Demolition of single storey side extension and attached double garage and erection of a pair of 3 bedroomed semi-detached houses. Resubmission of BE/57/14
346 Chichester Road Bognor Regis

Thank you for your internet comments made on 9th October 2014 which has been recorded as **'an objection'** with the comments as follows:

Proposed Elevations

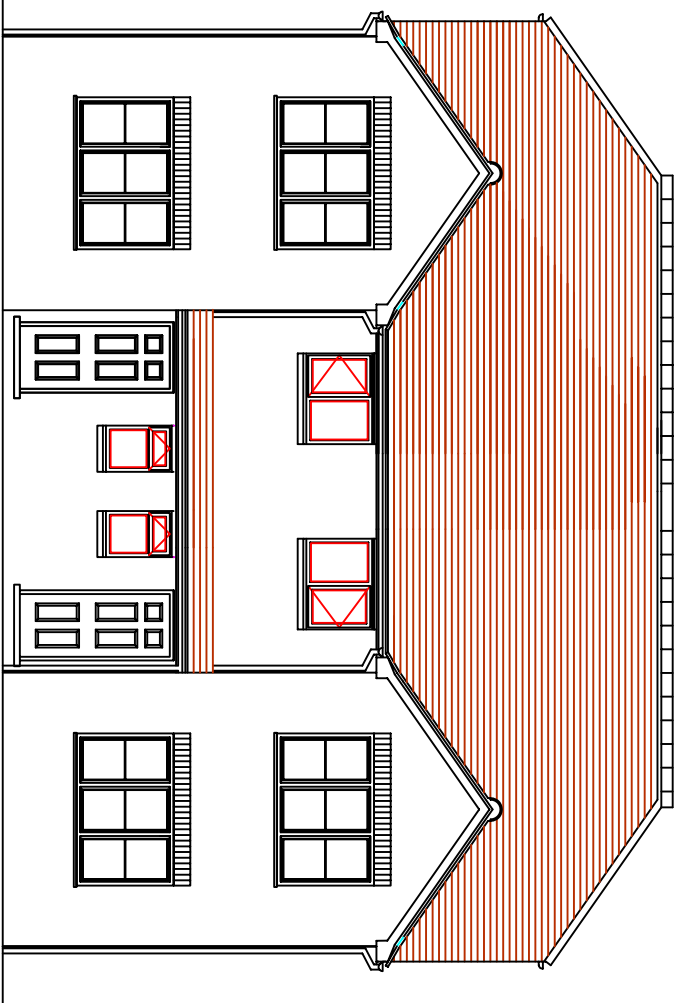
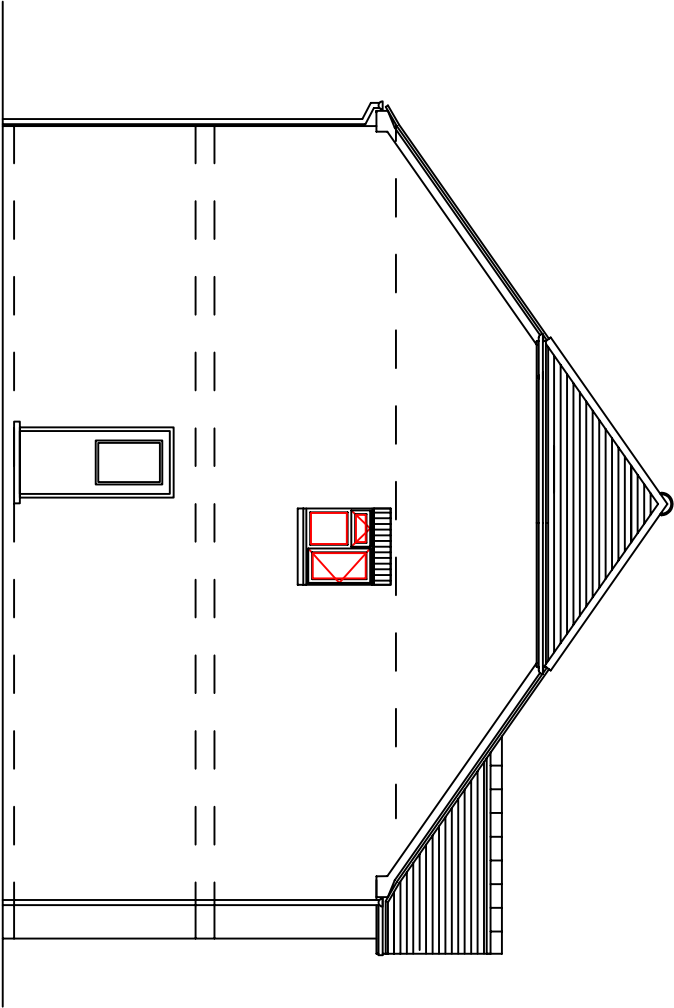
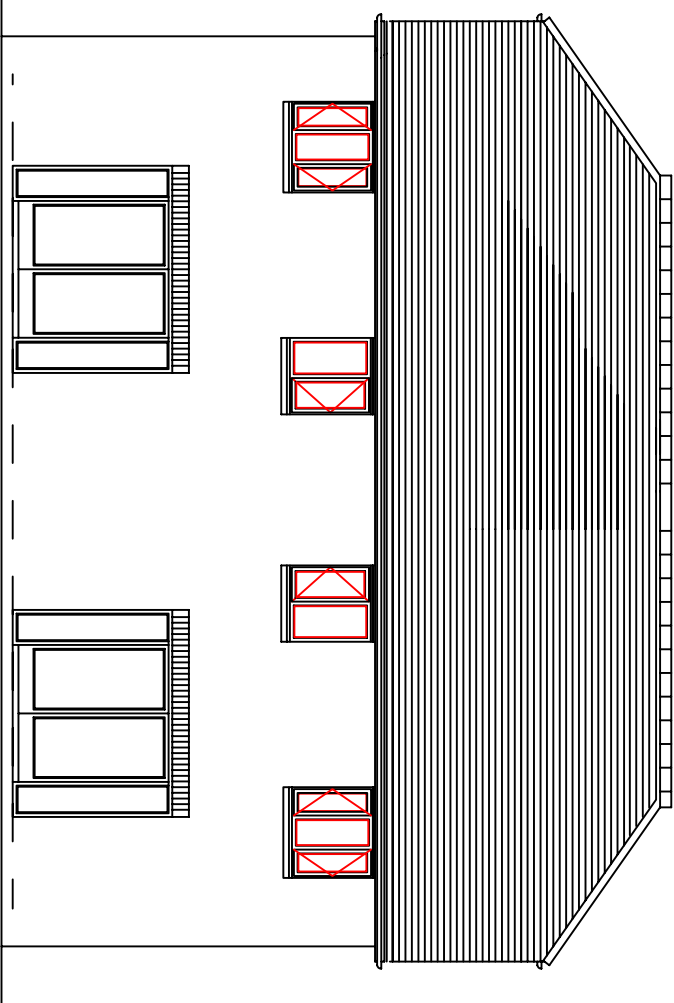
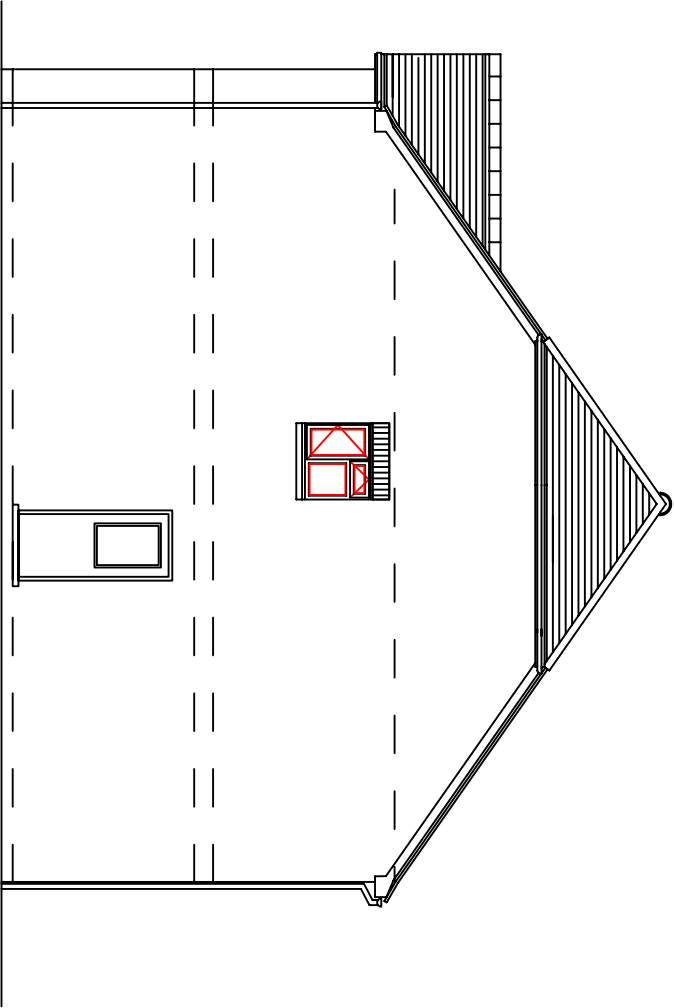
ES1 Design and Development the proposal has a roof height greater than the surrounding properties and would have an effect on the appearance and character of the surrounding area
